Appeal Decision

Appeal Ref: 6001249

113 Nield Road, Hayes, Hillingdon UB3 1SH

- The appeal is made under section 78 of the Town and Country Planning Act 1990 (as amended) against a refusal to grant planning permission.
 - The appeal is made by Mr Arvind & Mrs Dina Vaghela against the decision of the Council of the London Borough of Hillingdon.
 - The application Ref is 60552/APP/2025/2102.
 - The development proposed is a proposed First Floor side extension over existing garage space.
-

TITLE: PROPOSED SITE PLAN

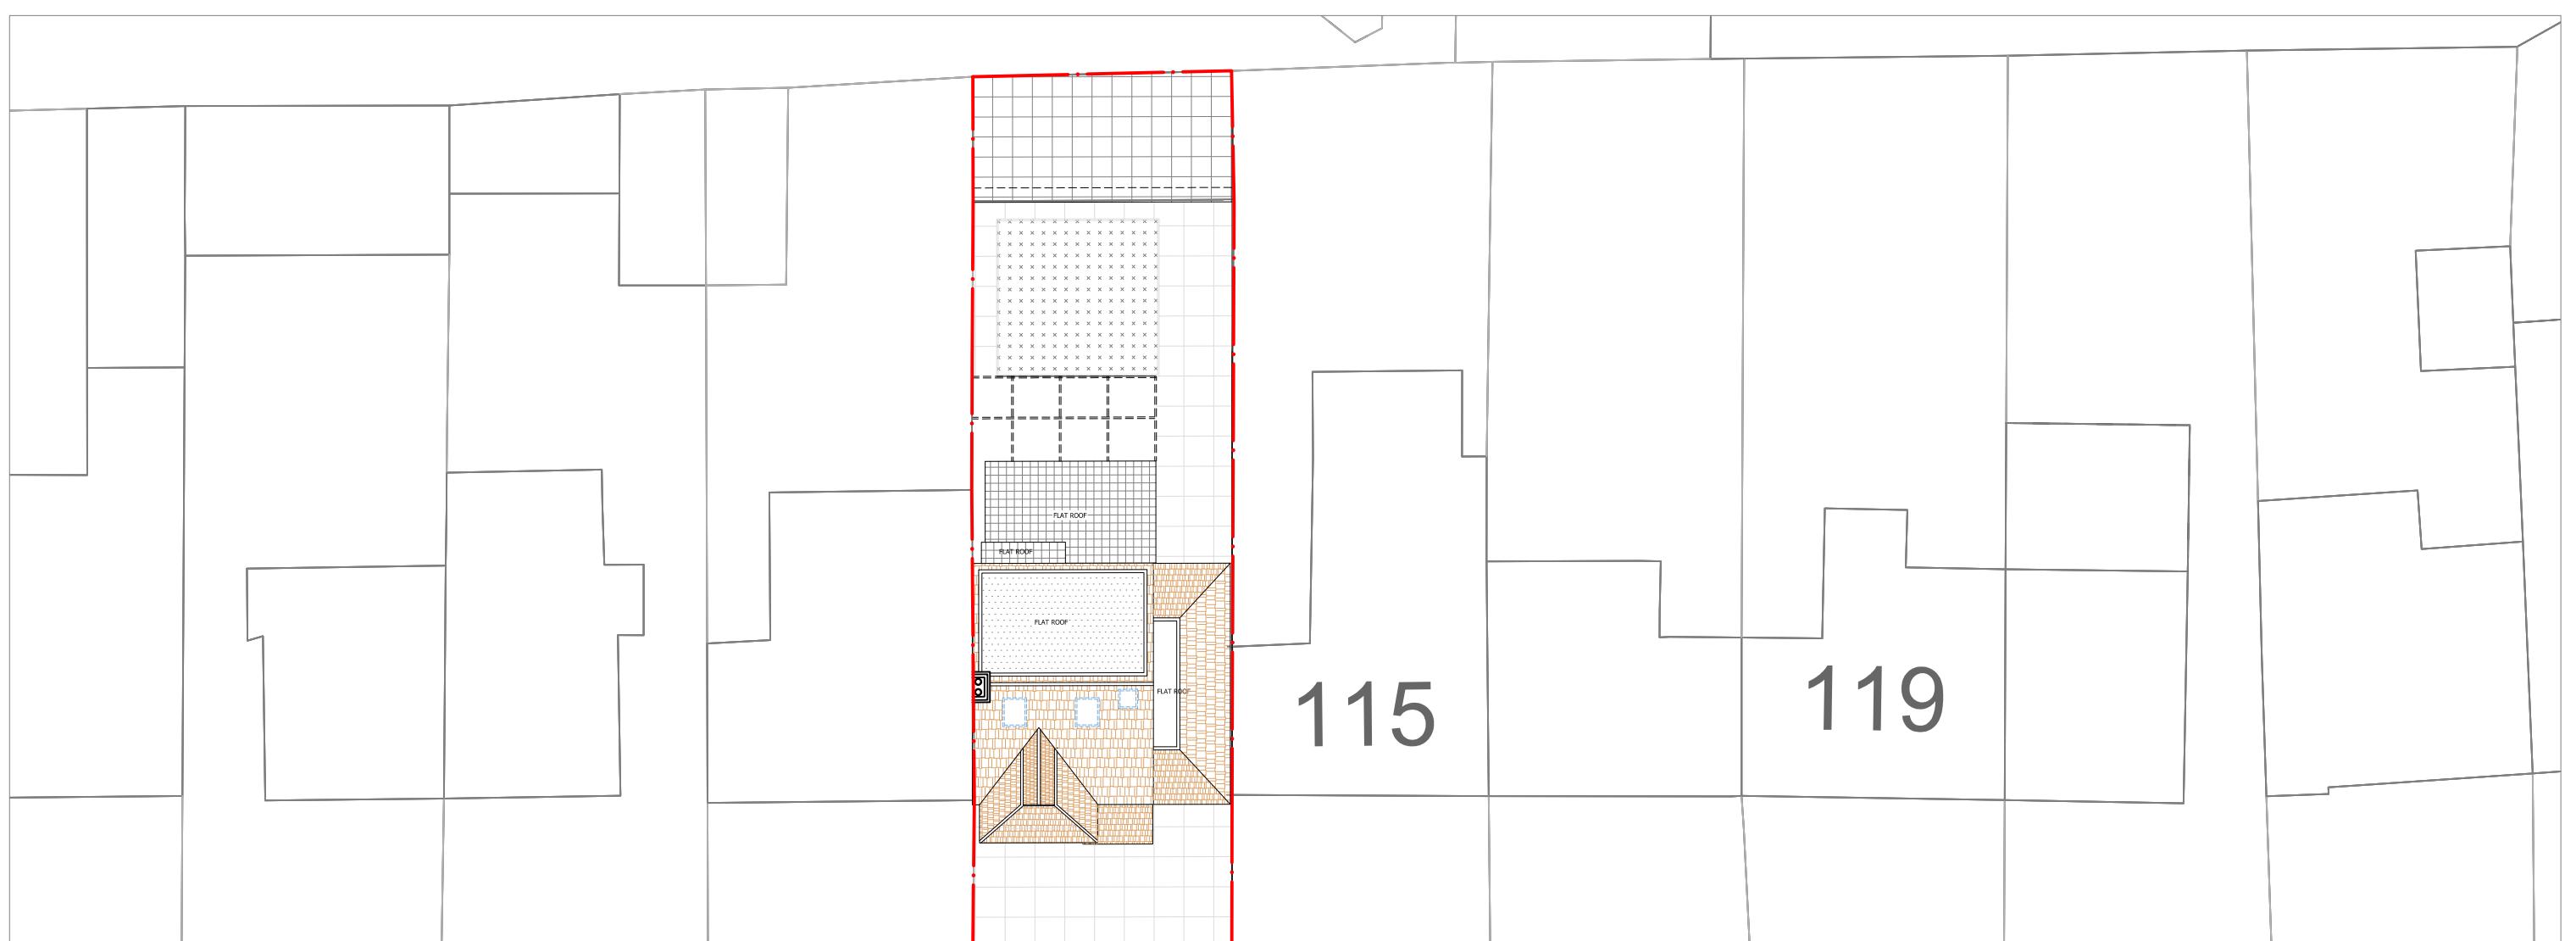
8. The proposed development would result in marginal loss of an area of outdoor hardstanding. This area is located between the rear elevation of the existing ground floor garage, side elevation of the host dwelling and the shared boundary.

9. Given the siting of this area and the extent of the remaining outdoor amenity space provided within the garden, it is unlikely that this area provides a usable or preferred area of outdoor space for the occupants. As such, whilst the proposed development would result in a very small reduction in the total garden space, I am satisfied that the occupants of the appeal dwelling would retain an ample amount of garden space for their outdoor enjoyment.

TITLE: PROPOSED ELEVATION & SECTION BB

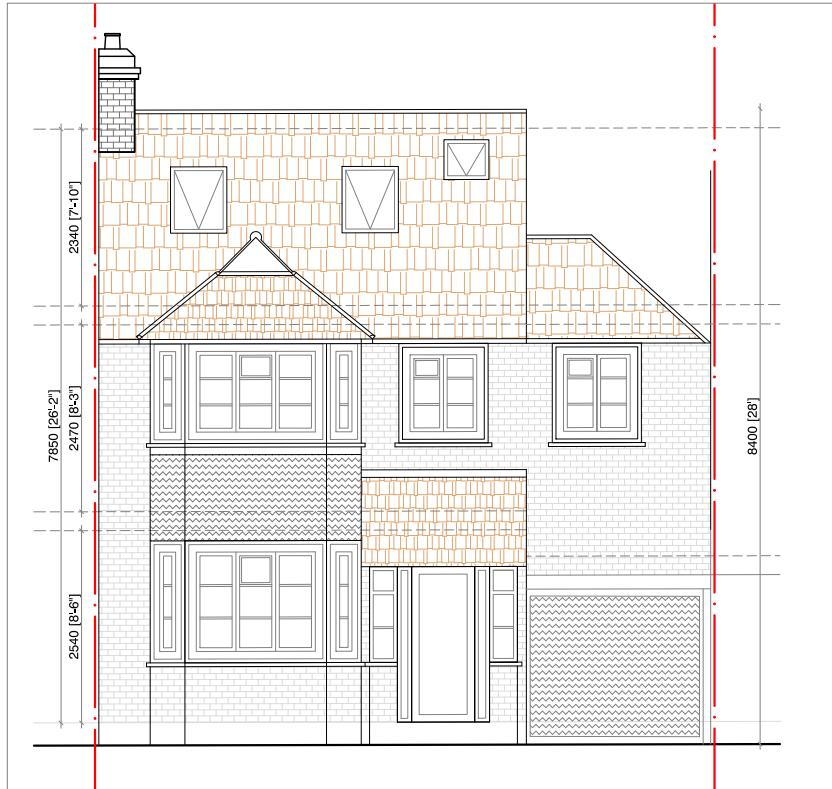
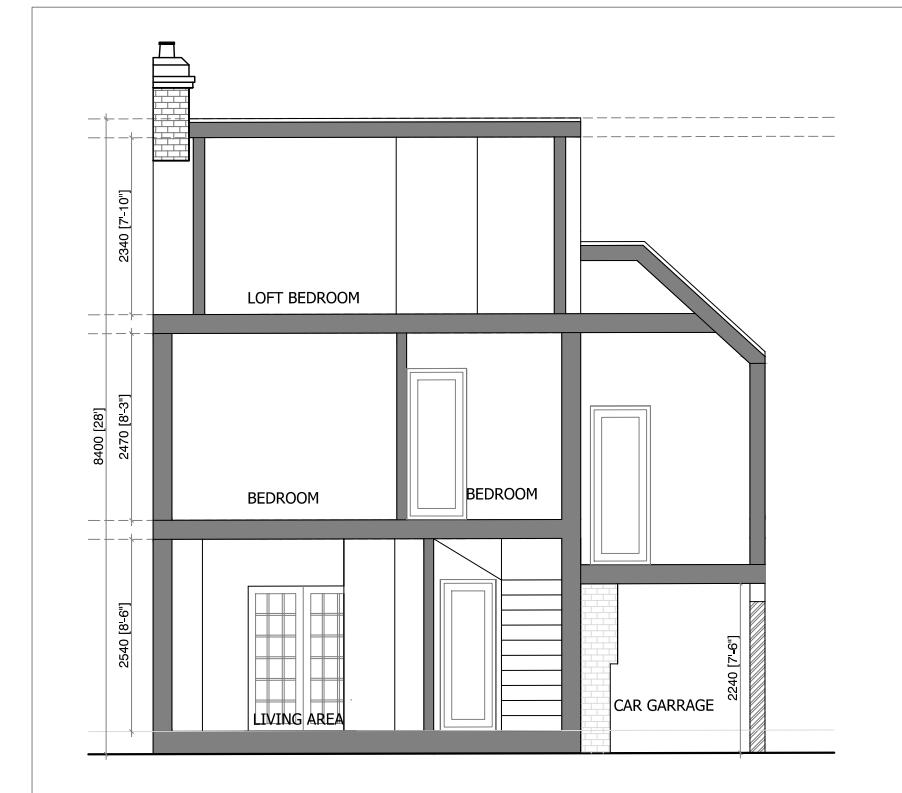
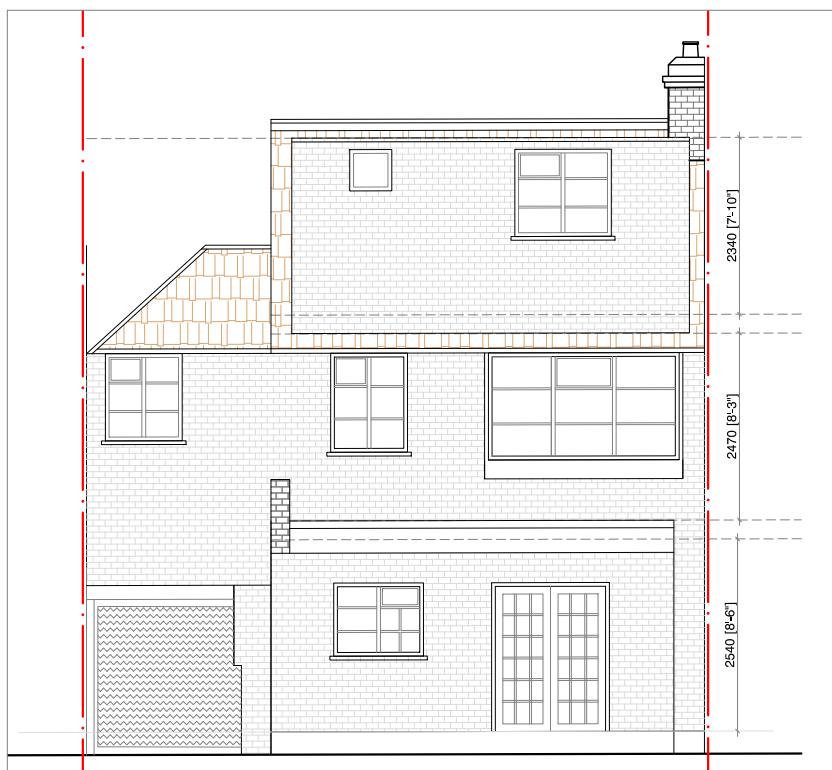
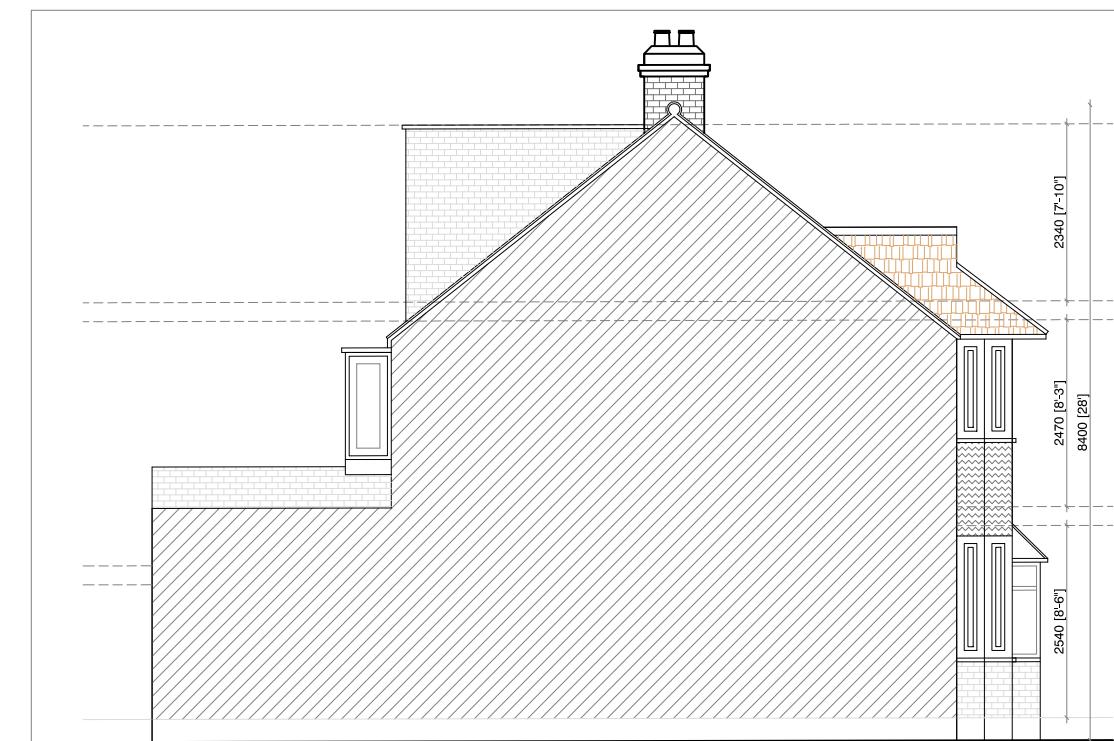
5. The appeal site comprises a two storey, semi-detached dwelling and it is similar in form and style to that of its neighbours. The proposed development would introduce a two storey side extension. Whilst the roof would be set down from the existing ridge, the extension would be flush with the front elevation of the host dwelling. It would span the full width of the plot and reach the shared boundary with 115 Nield Road.

6. Whilst the roof ridge would be subordinate to the main dwelling; it would feature a crown roof, and this would not reflect the form and design of the existing dwelling. This, in conjunction with the proximity of the extension to the boundary for full two storey height would result in a cramped appearance and reduce the gap at first floor level that is a feature of the locality.

7. For these reasons, I conclude that the proposed development would harm the character and appearance of the host dwelling and area. I therefore find conflict with Policy BE1 of the Hillingdon Local Plan: Part One (HLP Part One), Policies DMHB 11, DMHB 12 and DMHD 1 of the Hillingdon Local Plan: Part Two – Development Management Policies (January 2020) (HLP Part Two), and Policies D3 and D4 of the London Plan (2021). These policies, among other things, aim to ensure that development is of high quality design, harmonises with the local context and that extensions achieve a satisfactory relationship with the host dwelling. I also find conflict with the National Planning Policy Framework (2024) (the Framework) which promotes well designed places through developments being sympathetic to local character.
